Subject: Ranch Road Performance Based Cluster Plat (LPF-19-00002) Final Plat. – Staff Review and Request for Additional Information

TO: Community Development Services
FROM: Taylor Gustafson, Environmental/Transportation Planner
DATE: March 22, 2019
SUBJECT: Ranch Road Final Cluster Plat (LPF-19-00002)

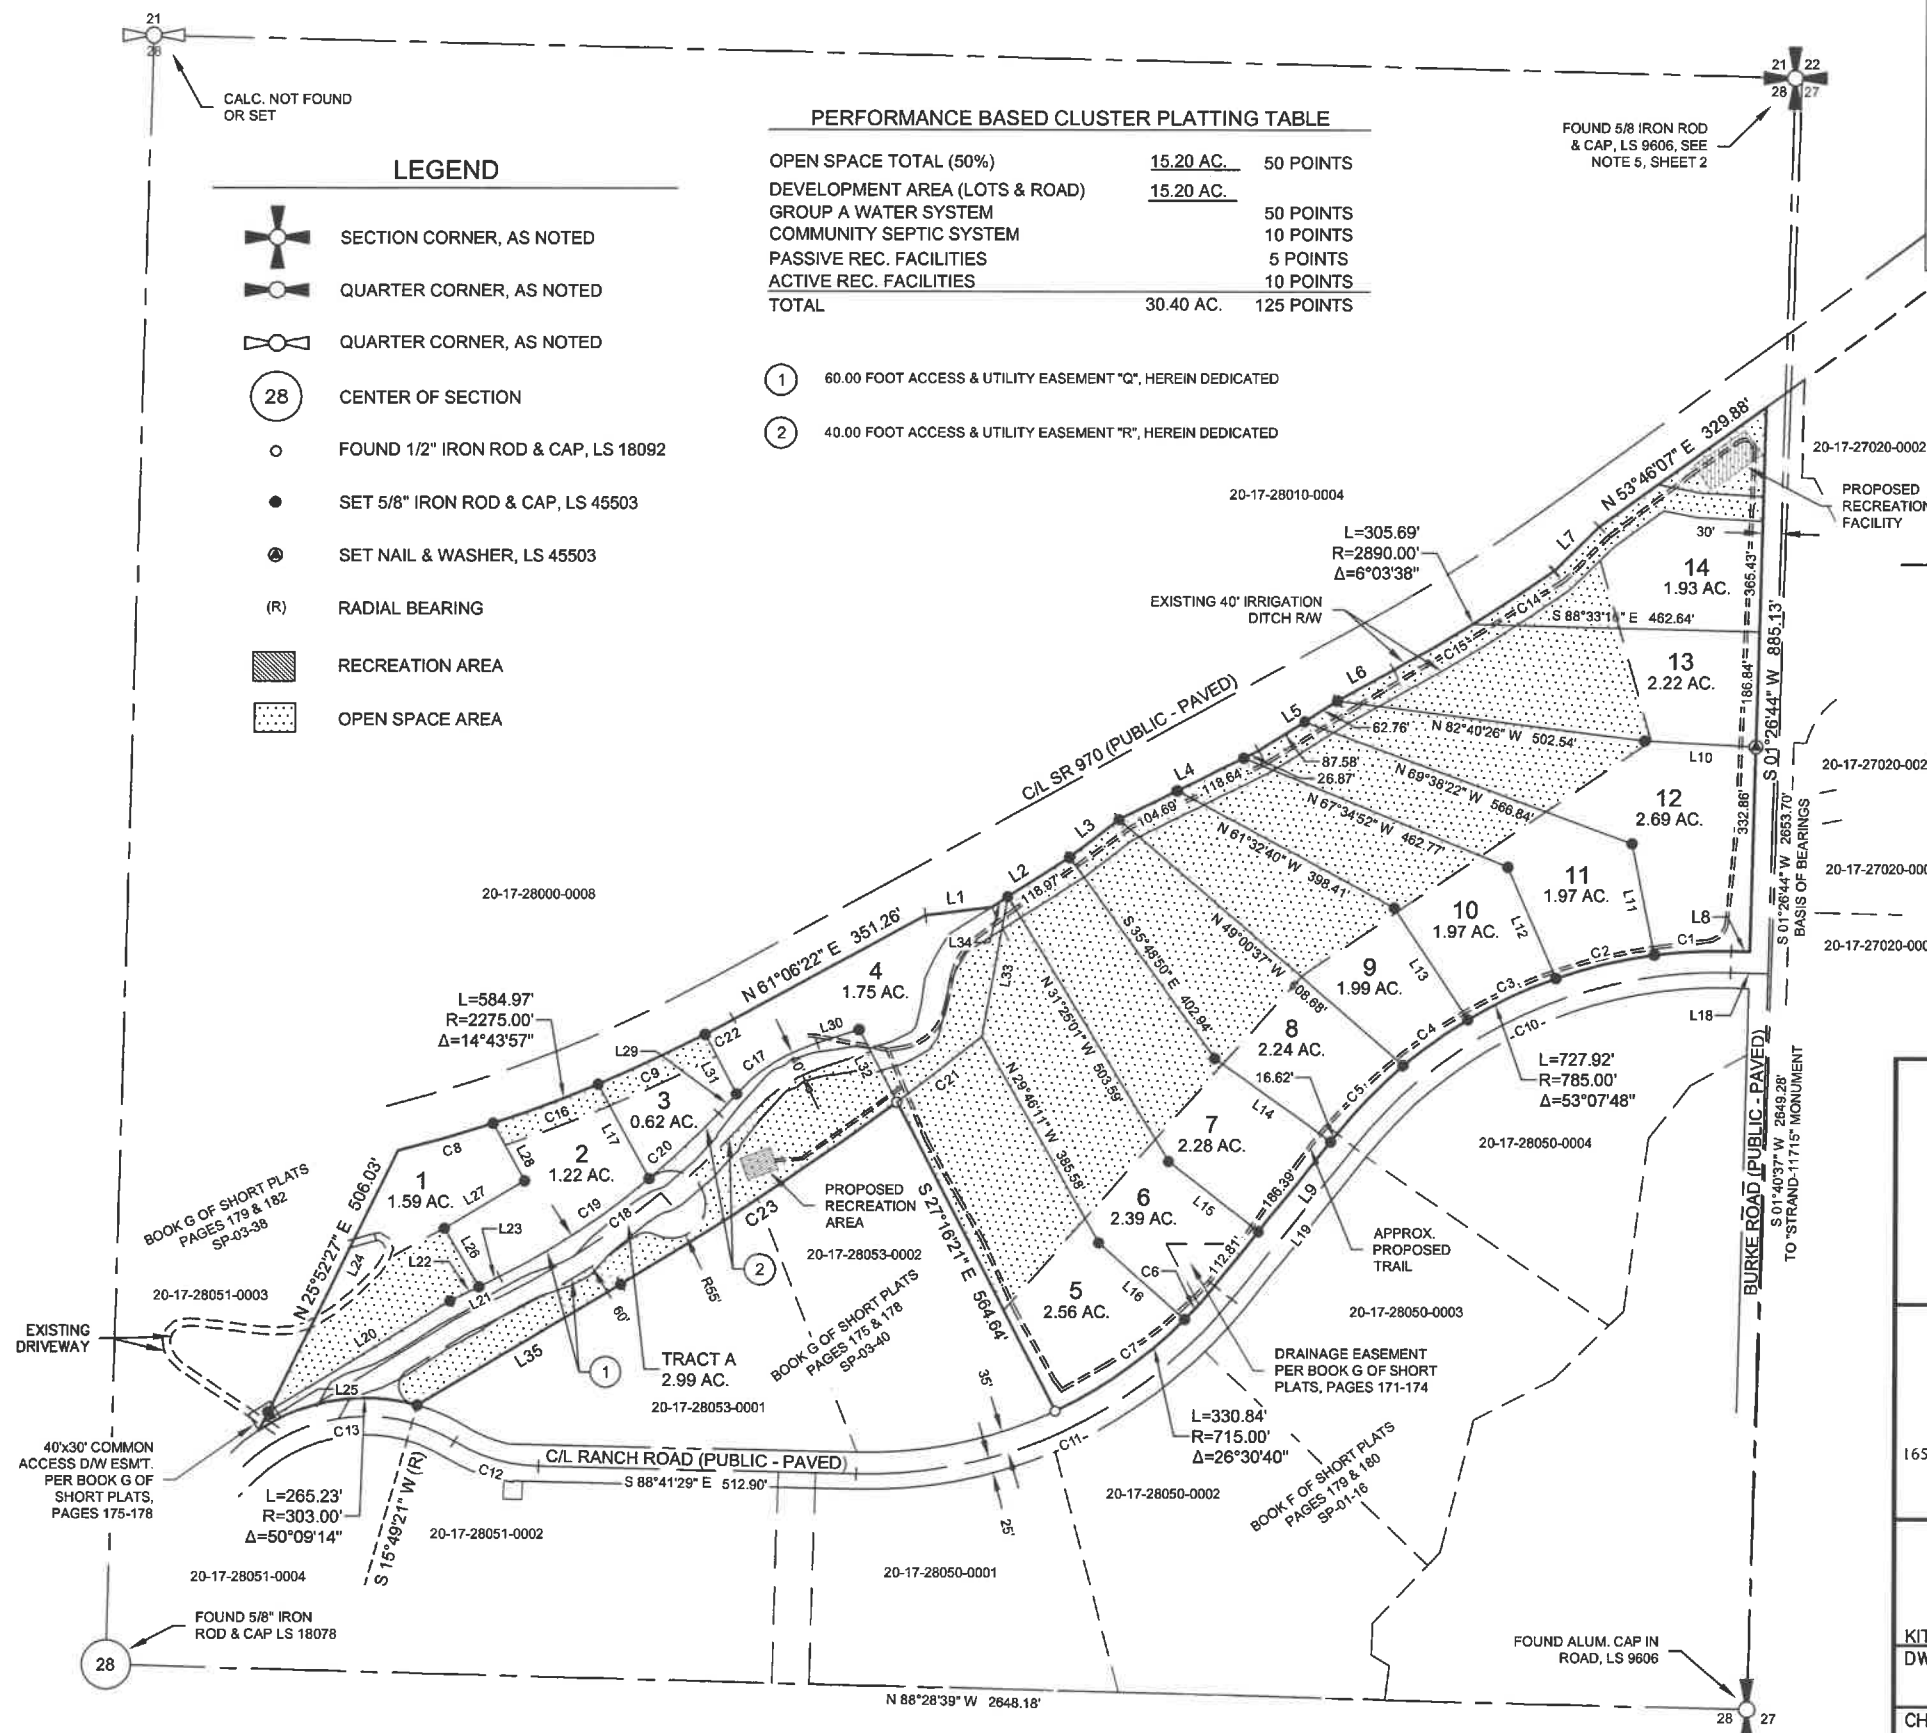
- 1) An access easement needs to be shown on the face of the plat for lot 1.

Sheet 1:

- 1) The dimensions for the North line of Lot 13, and the Northeast line of Lot 8 are obscured by crossing linework.
- 2) The division line between lots 13 and 14 should be monumented in the field.

- 3) The ownership of the public right of way should be clarified as being county or state.
 - a. EX: "Burke Rd- County R/W –Paved"
- 4) The open space limits are not retraceable/locatable.

- 5) The existing driveway serving lot 1 should include reference to the 20 foot access easement recorded under AF 2019031300003.
- 6) The access easement serving lots 2, 3, and 4 should be shown as dedicated right of way OR clear language included on the face of the plat that the entirety of Tract A shall fall under the ownership of a homeowners association, so as to protect the county from undesired ownership through absentee land tax.
